Site of Former Spotted Cow Pub, New Hey Road, Oakes, Huddersfield – Discharge of details reserved by condition 23 (surface water) of previous permission 2021/94029 for demolition of existing structures and erection of foodstore (class E) with associated access, parking, servicing areas and landscaping

Yorkshire Water objects to discharge condition 23.

The drainage details submitted on drawing, Drainage Arrangement Sheet 1 OF 2 16-3046-101 (revision P01) dated August 2024 prepared by Cora iHt requires amendments. The following points should be addressed:

P1	AUG 24	FIRST ISSUE	GRE
Rev	Date	Revision Details	By Chkd Appd
CoraⁱHiT			
Client: LIDL GREAT BRITAIN Ltd			
Project: NEW HEY ROAD			
Title: DRAINAGE ARRANGEMENT SHEET 1 OF 2			
Drawing No.	16-3046-101	Revision	P1
Scale	1:250 @ A1	Date	AUGUST 2024
Drawn	GRE	Chk	App

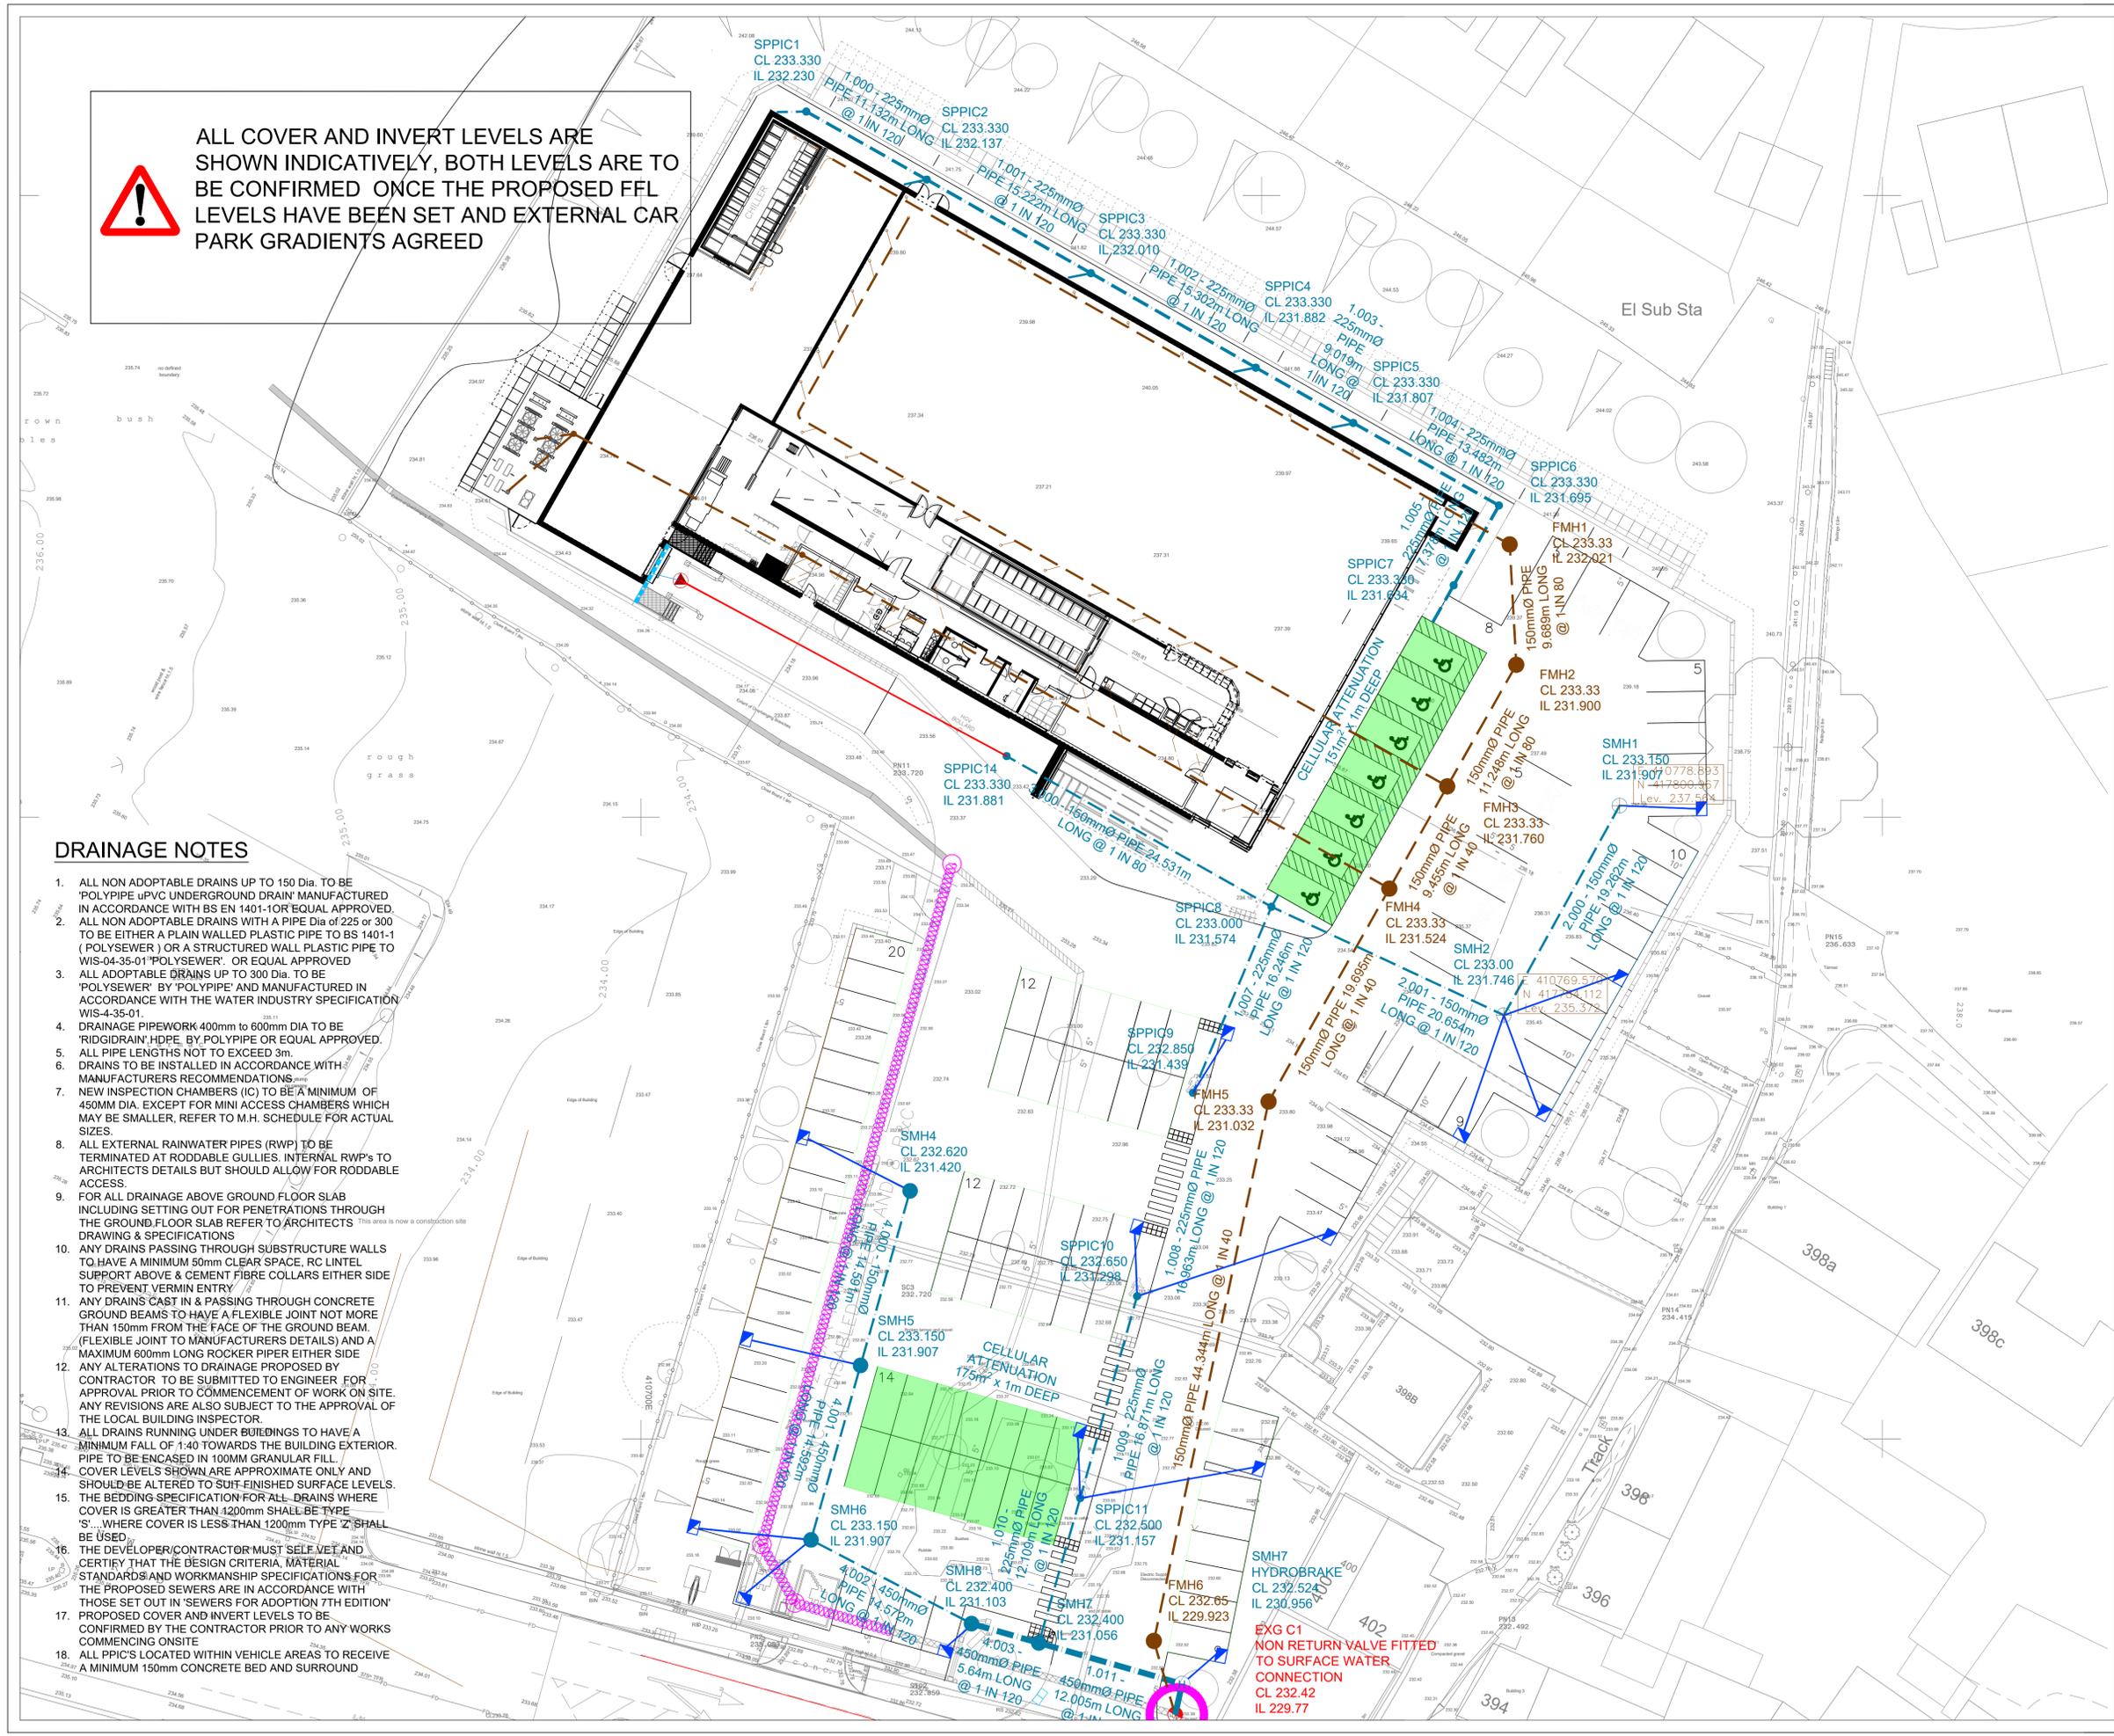
- i) the submitted drawing indicates chamber SMH7 with hydrobrake however the hydrobrake appears to be in the following chamber downstream. Please amend accordingly.
- ii) the submitted drawing should note the flow control rate on the plan.
- iii) the submitted drawing indicates that there should be a 225 mm diameter pipe between SPPIC9 and SPPIC10 but no connecting pipe is shown on the plan. Please amend accordingly.
- iv) the direction of flow for the surface water should be shown on the plan.
